CITY OF ALBUQUERQUE

**RE: Mesa Del Sol Self Storage
5500 Turing Dr. SE
Grading and Drainage Plan
Engineer's Stamp Date: 01/15/2025
Hydrology File: R16DA1004**

Based upon the information provided in your submittal received 02/07/2025, the Grading & Drainage Plan is approved for the **Foundation Permit**. The following conditions need to be addressed prior to approval of Building Permit:

SHEET NUMBER: **C-3.1**

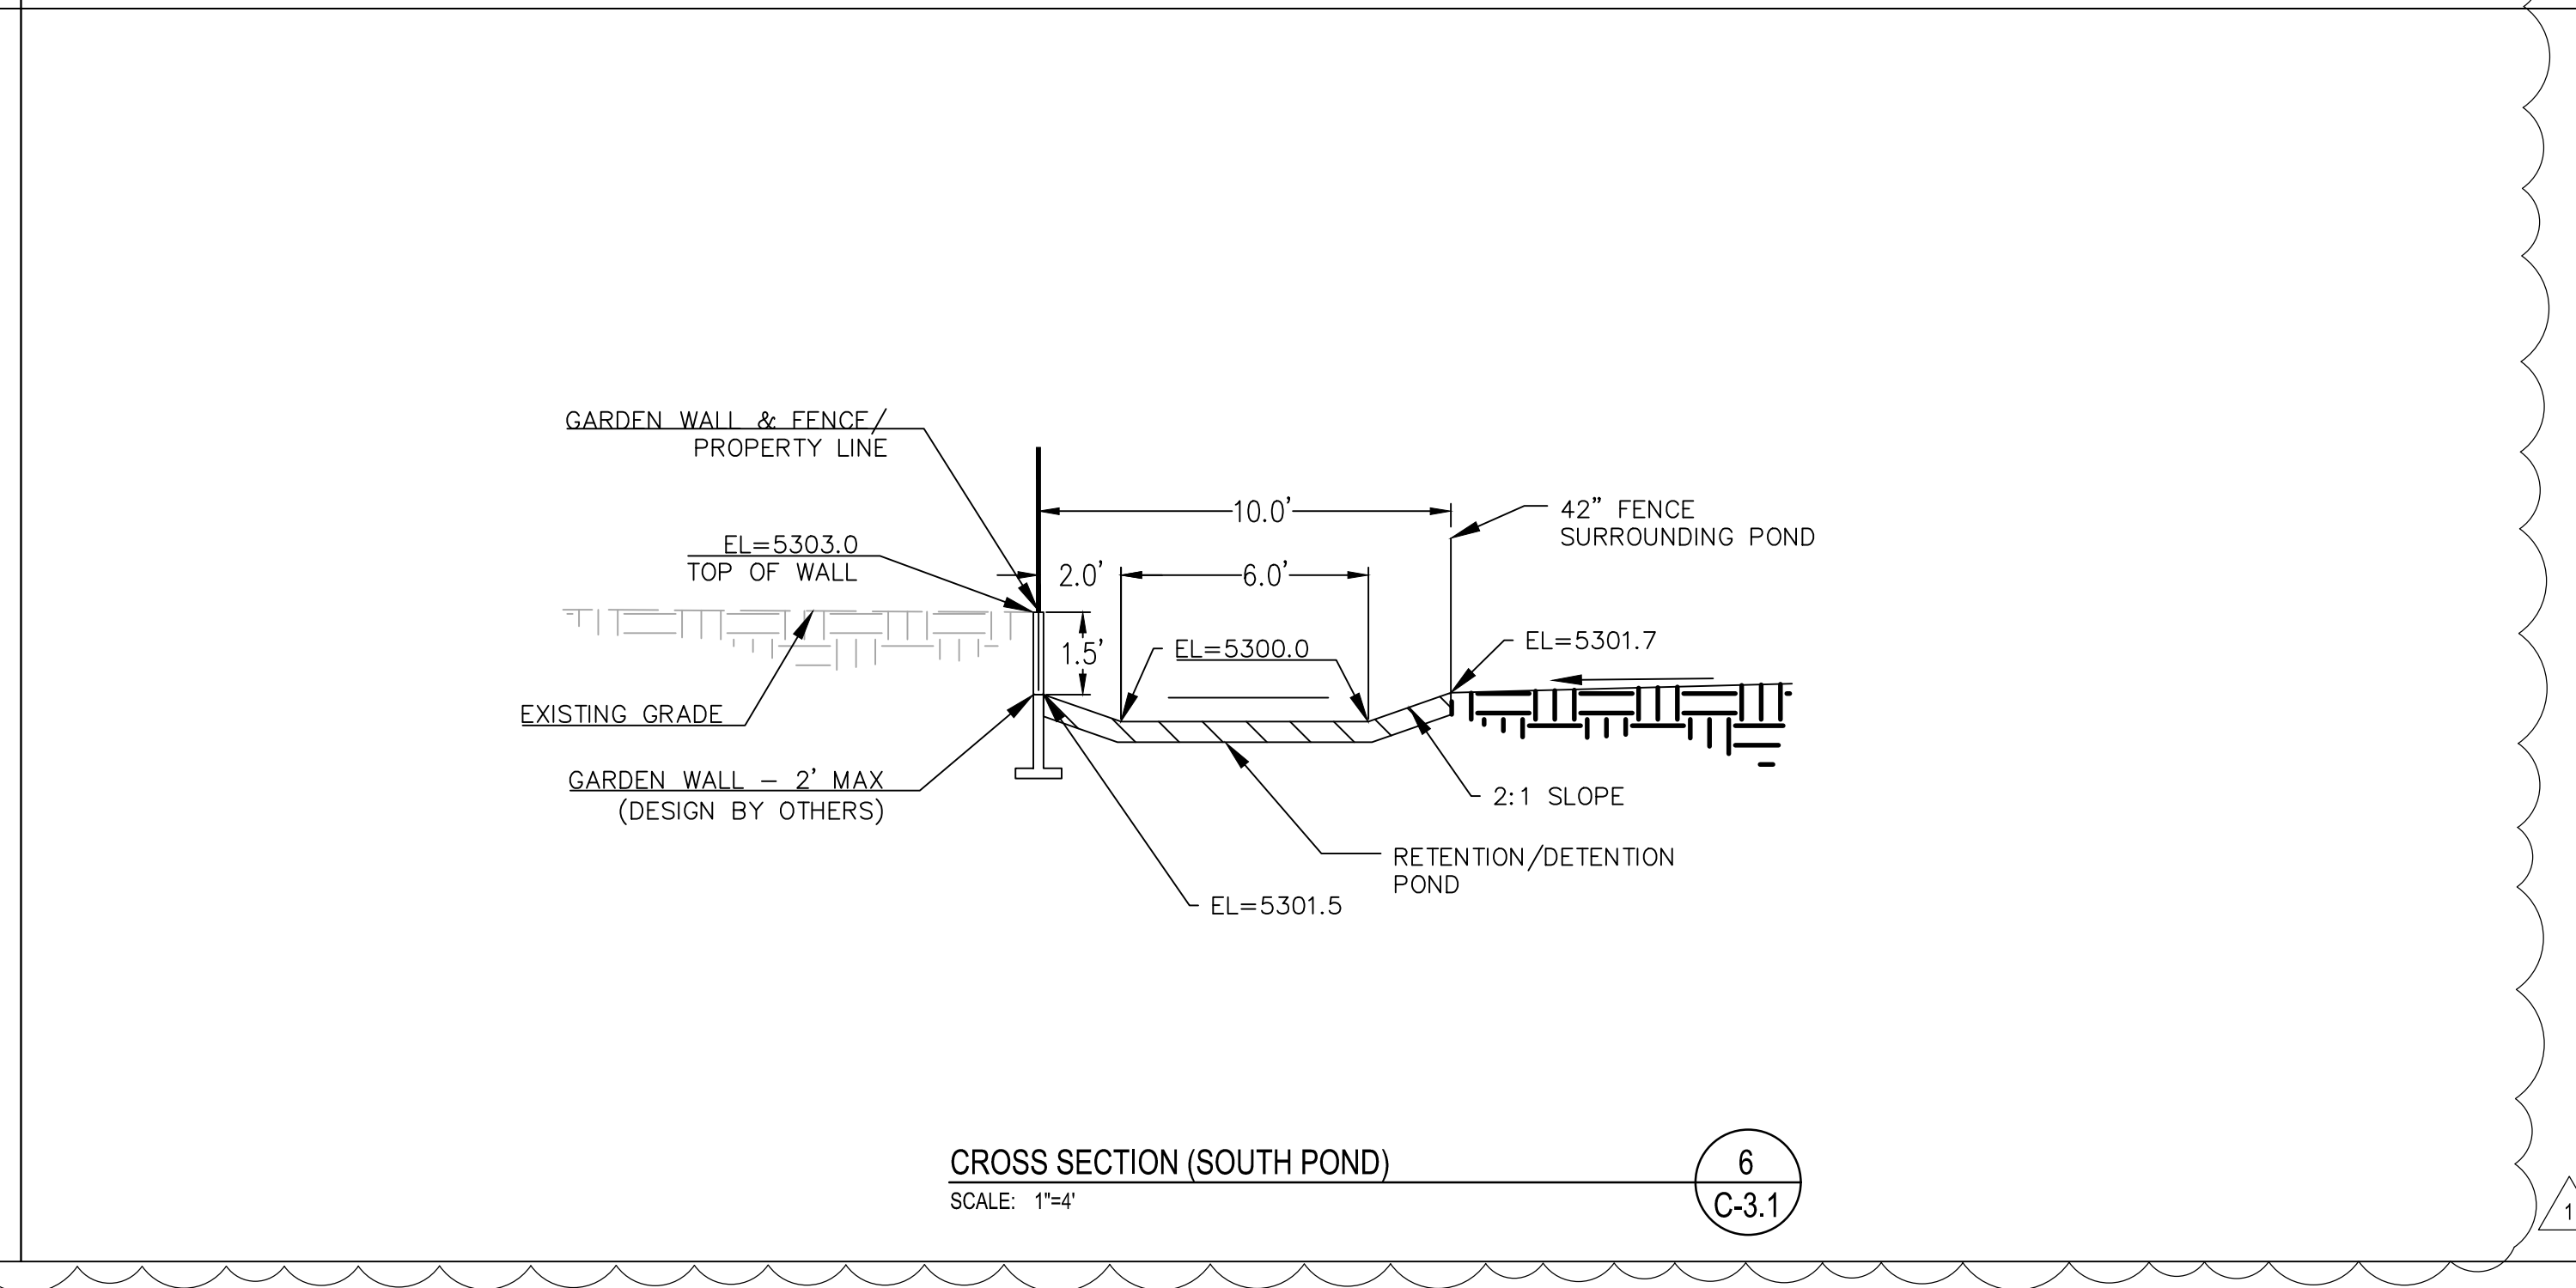
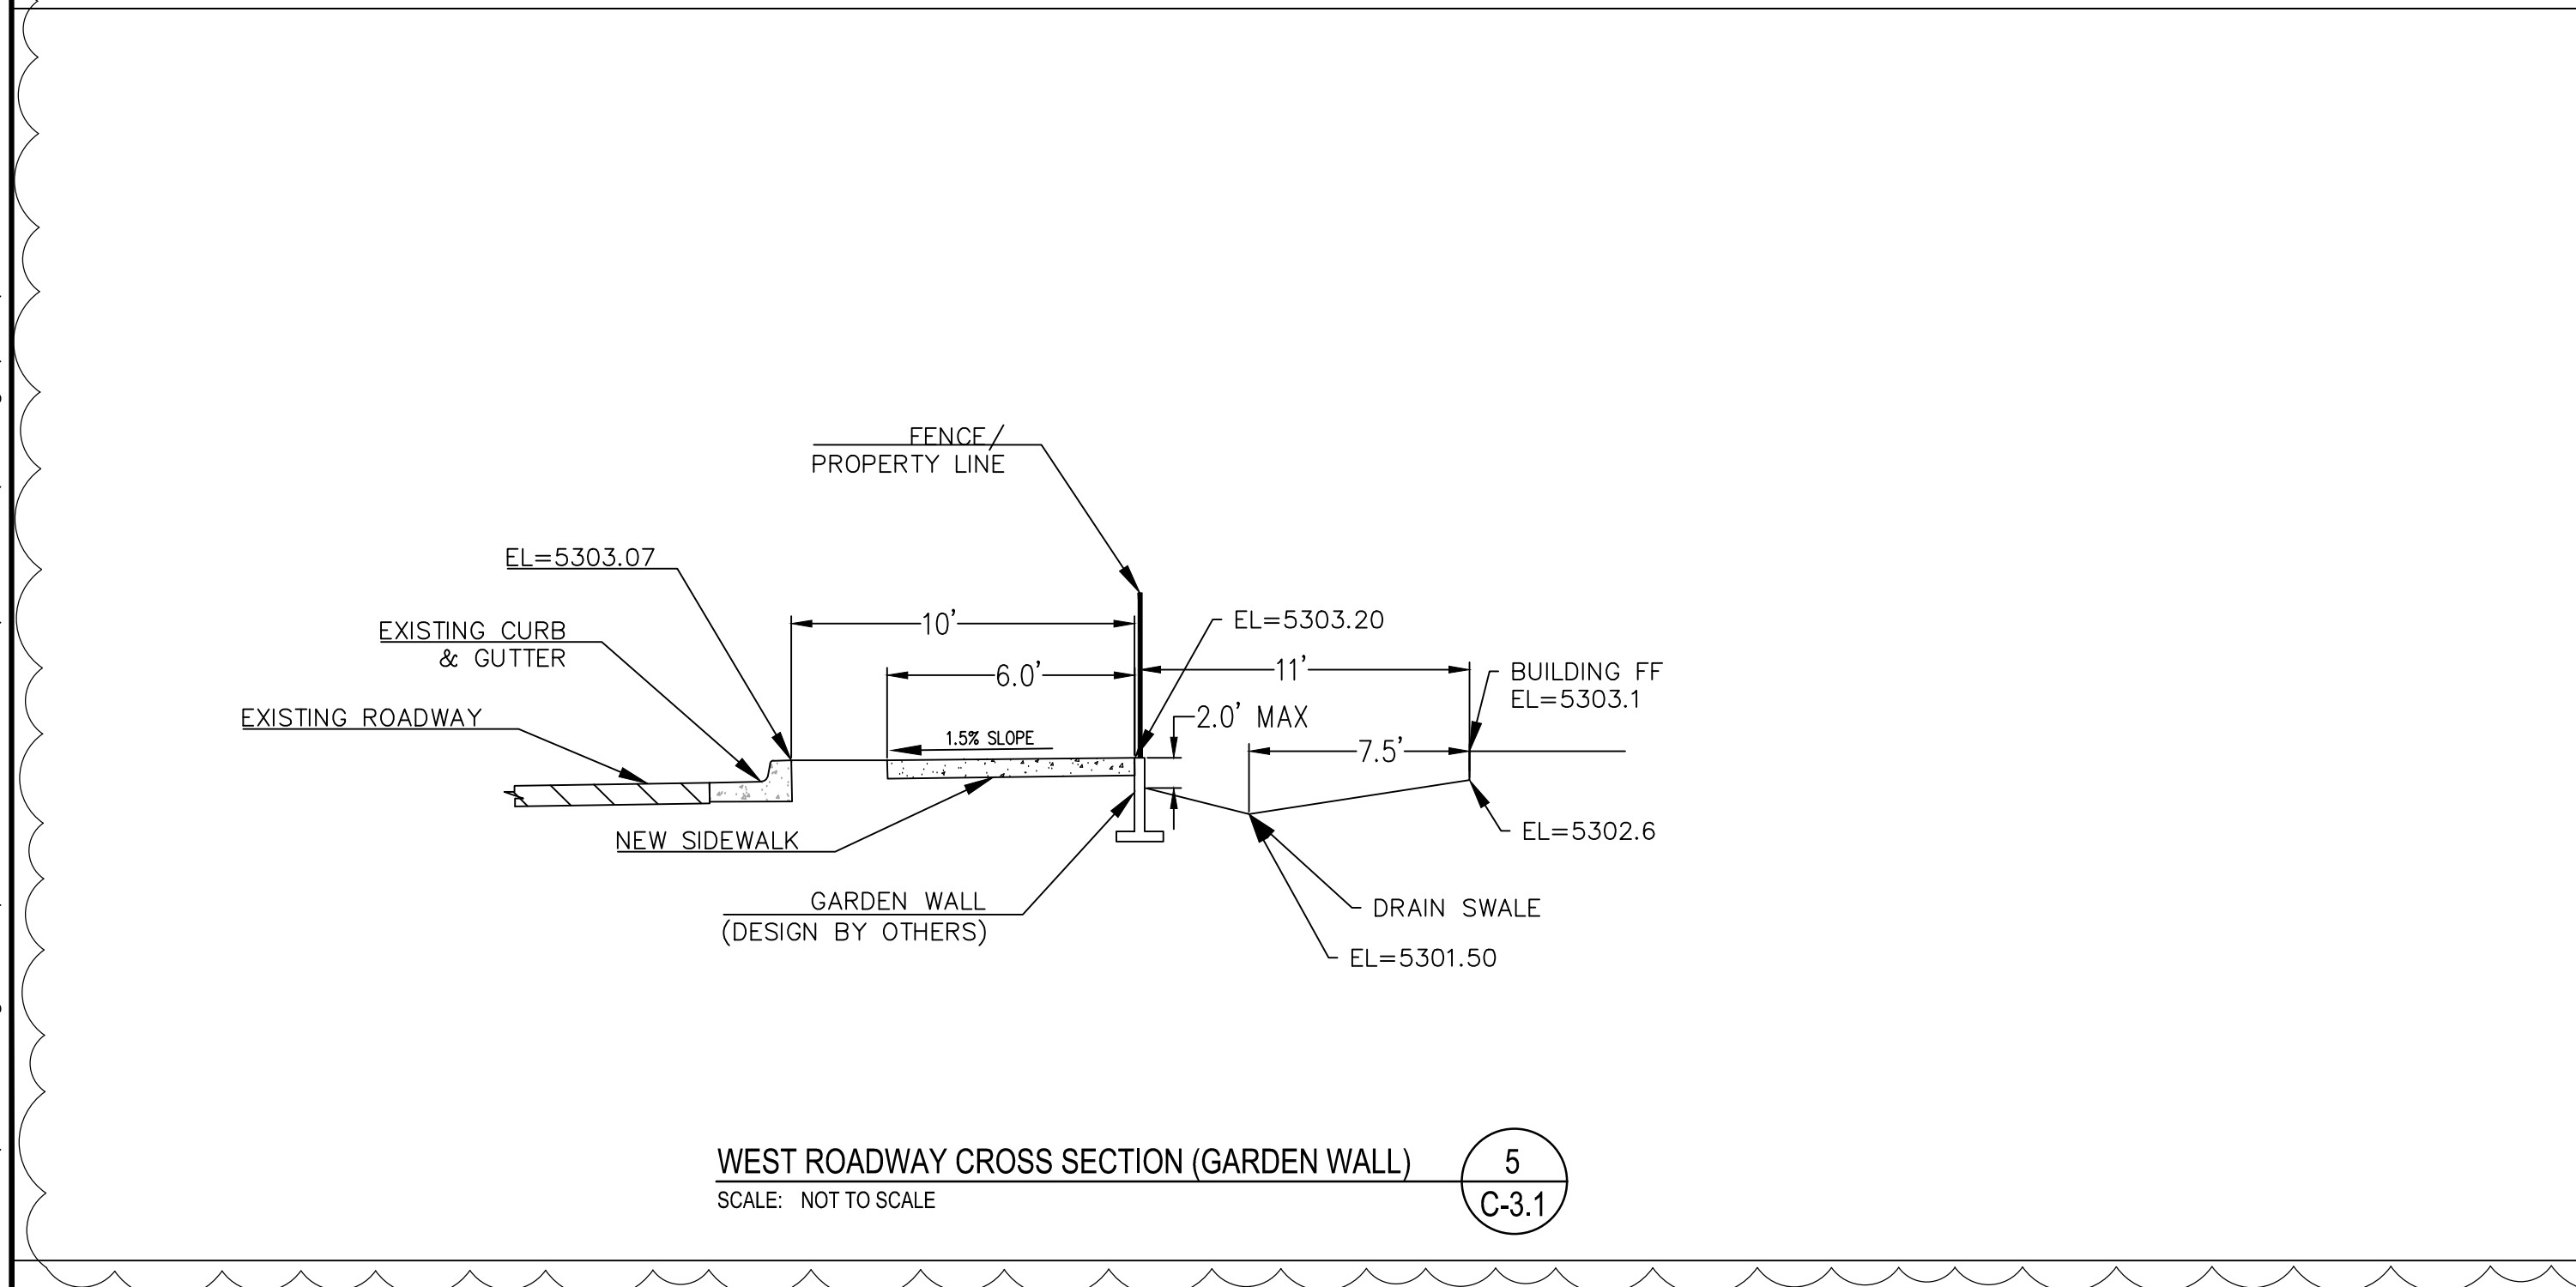
2. Due to the proposed retaining wall in Section 1 of C-3.1, provide an additional cross-section showing the existing storm drain manhole and pipe extension through the proposed retaining wall and into the retention basin at the southeast corner of the project.
